COUNTY COUNCIL'S RESPONSE TO CONSULTATION ON THE FOLLOWING DEVELOPMENT PROPOSAL

Application No: 18/00193/REM

Proposal: Reserved matters application to 14/02156/OUT - for appearance, landscaping and layout (including the layout of the internal access roads, footpaths and cycleways) for 44 dwellings

Location: Land South Of Cotefield Business Park Oxford Road Bodicote

Road 3  
Horiz. 1:500 Vert. 1:50

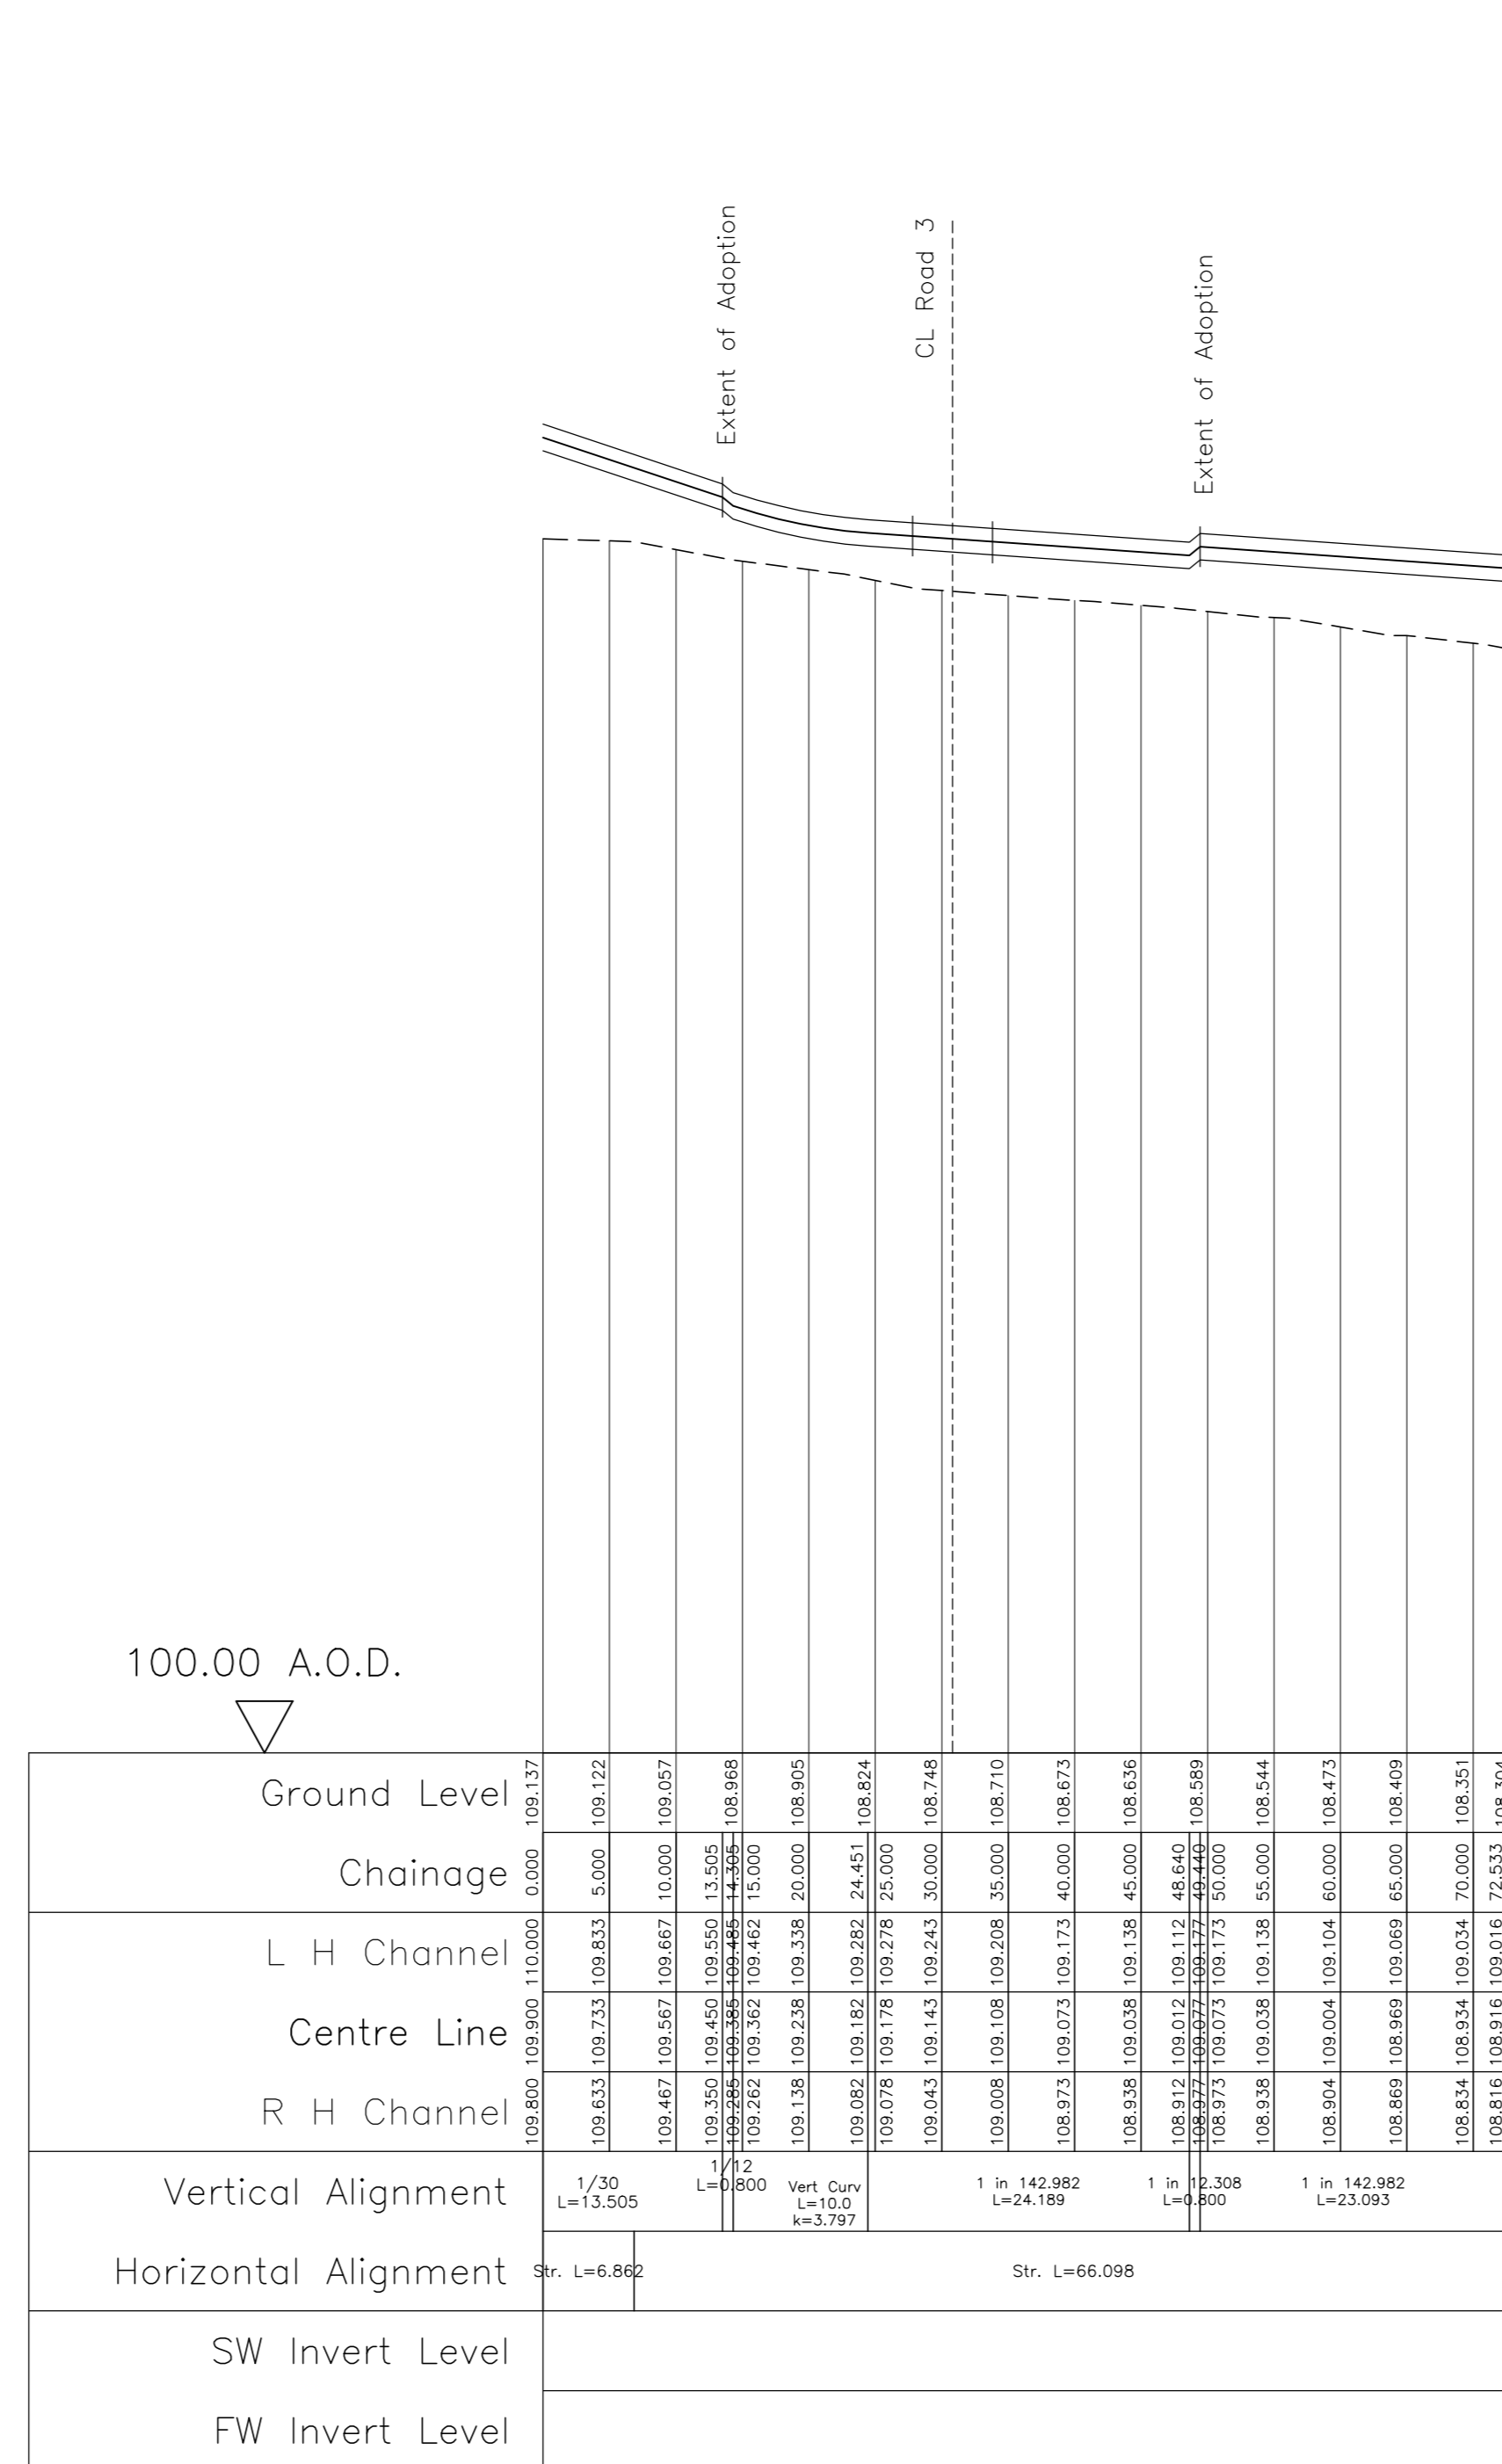
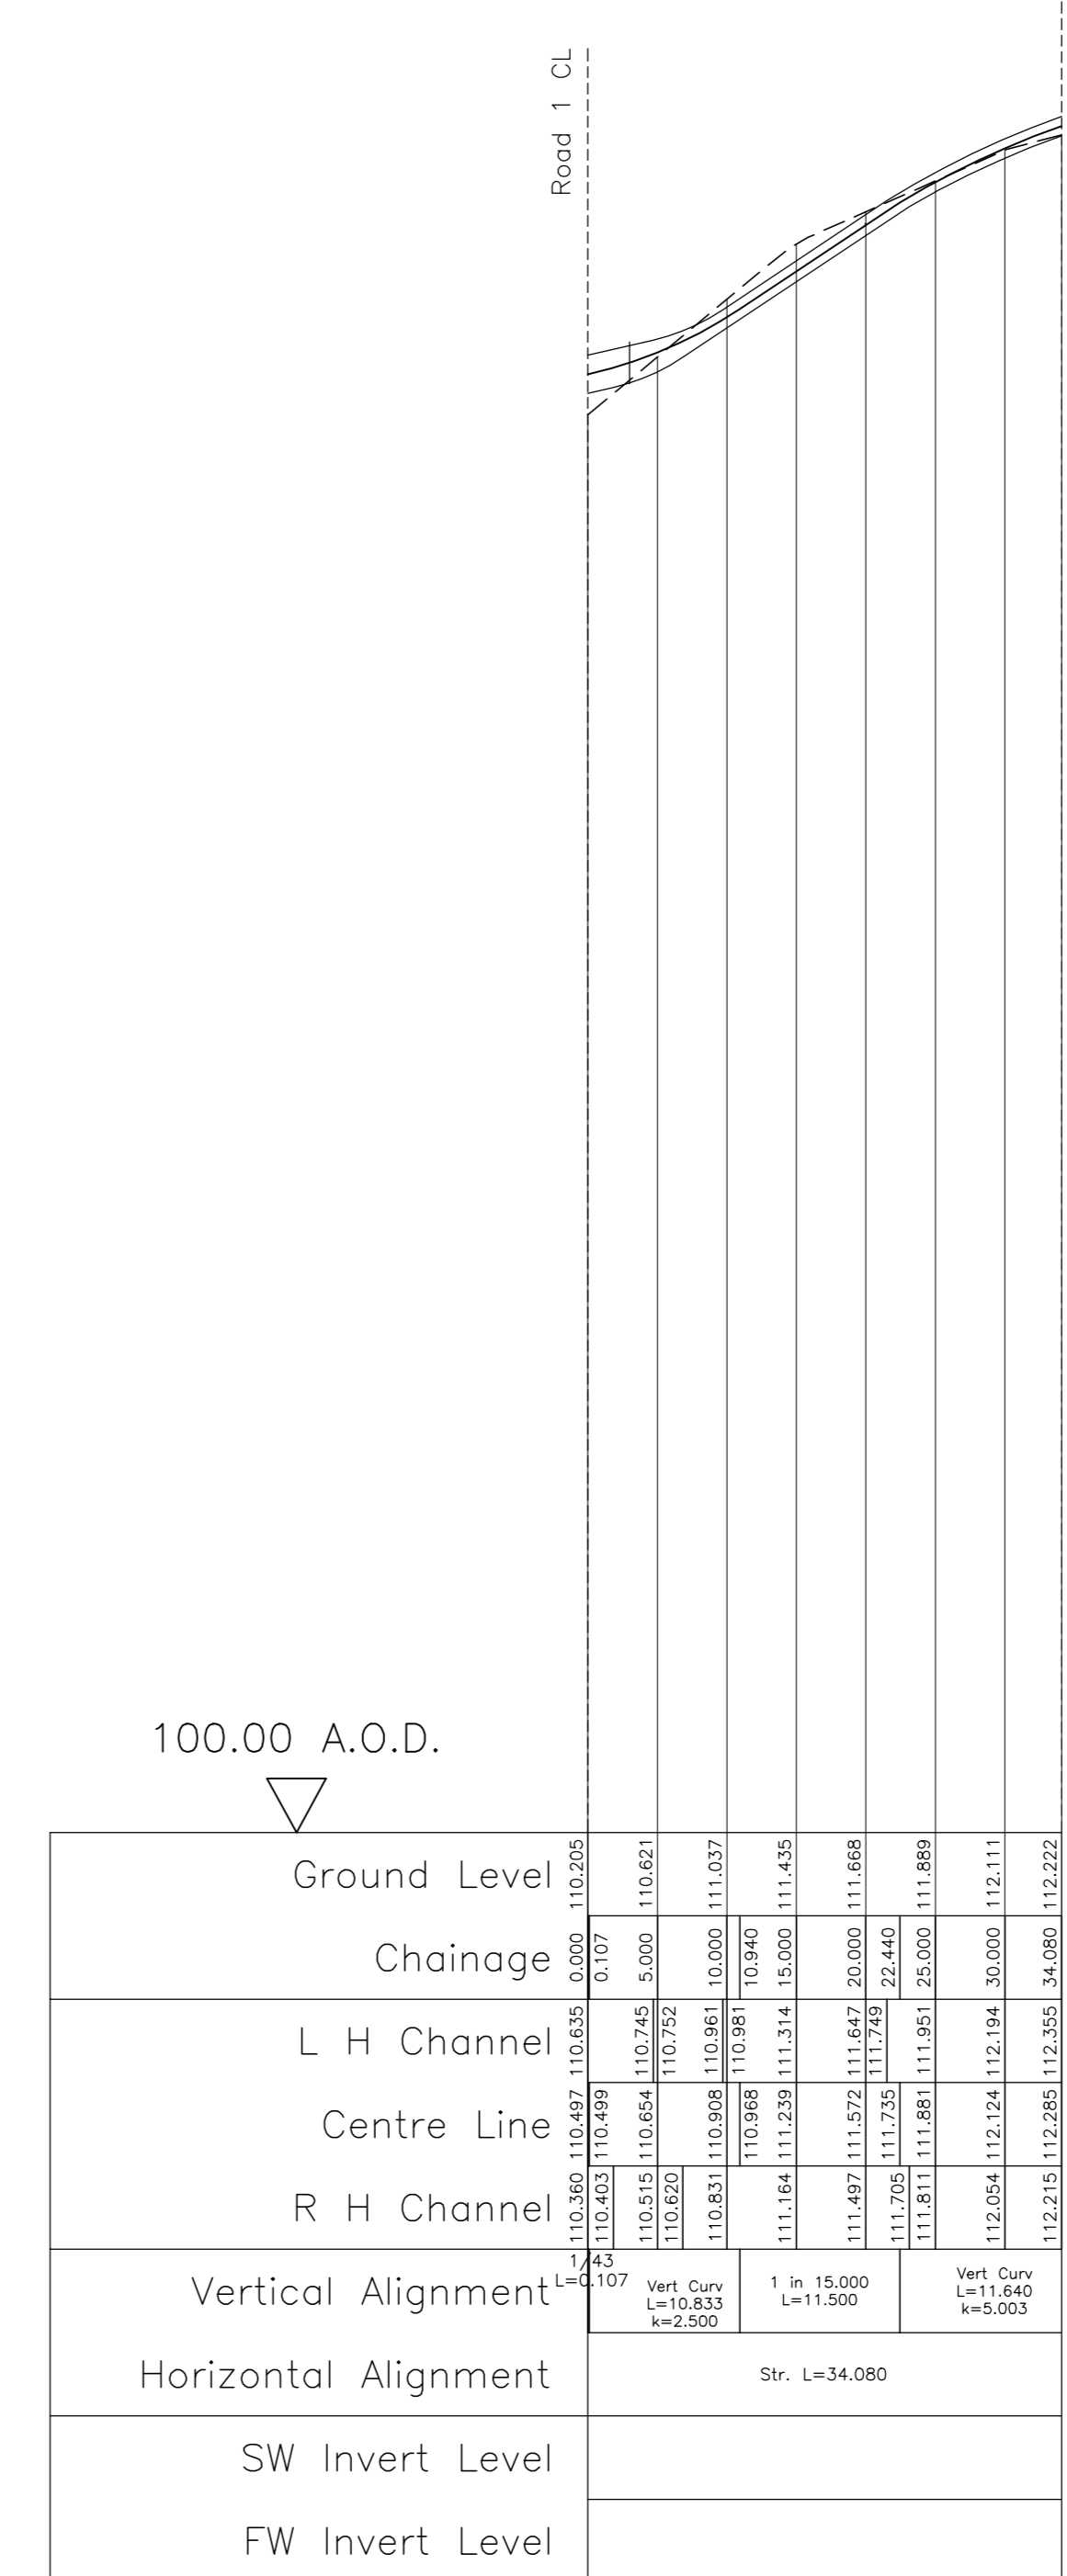
- This reserved matters application applies only to the layout of part of the site covered by the outline permission. It is difficult to assess pedestrian permeability without considering the layout of the whole site.
- Parking levels are very tight and rely on garages being counted as parking spaces.
- There is therefore a risk of on-street parking which could obstruct vehicular access and/or footways
- Refuse vehicle tracking at junction of Road 1 and Road 4 – vehicle uses whole of opposing carriageway when making the turn from Road 1 into Road 4, which may require vehicles waiting to exit Road 4 having to reverse, causing a safety risk.

The vehicle tracking has been carried out using a large refuse vehicle. There is an issue with the turn from Road 1 into Road 4 as described above. Additional visibility should be provided across plot 44 to reduce the risk.
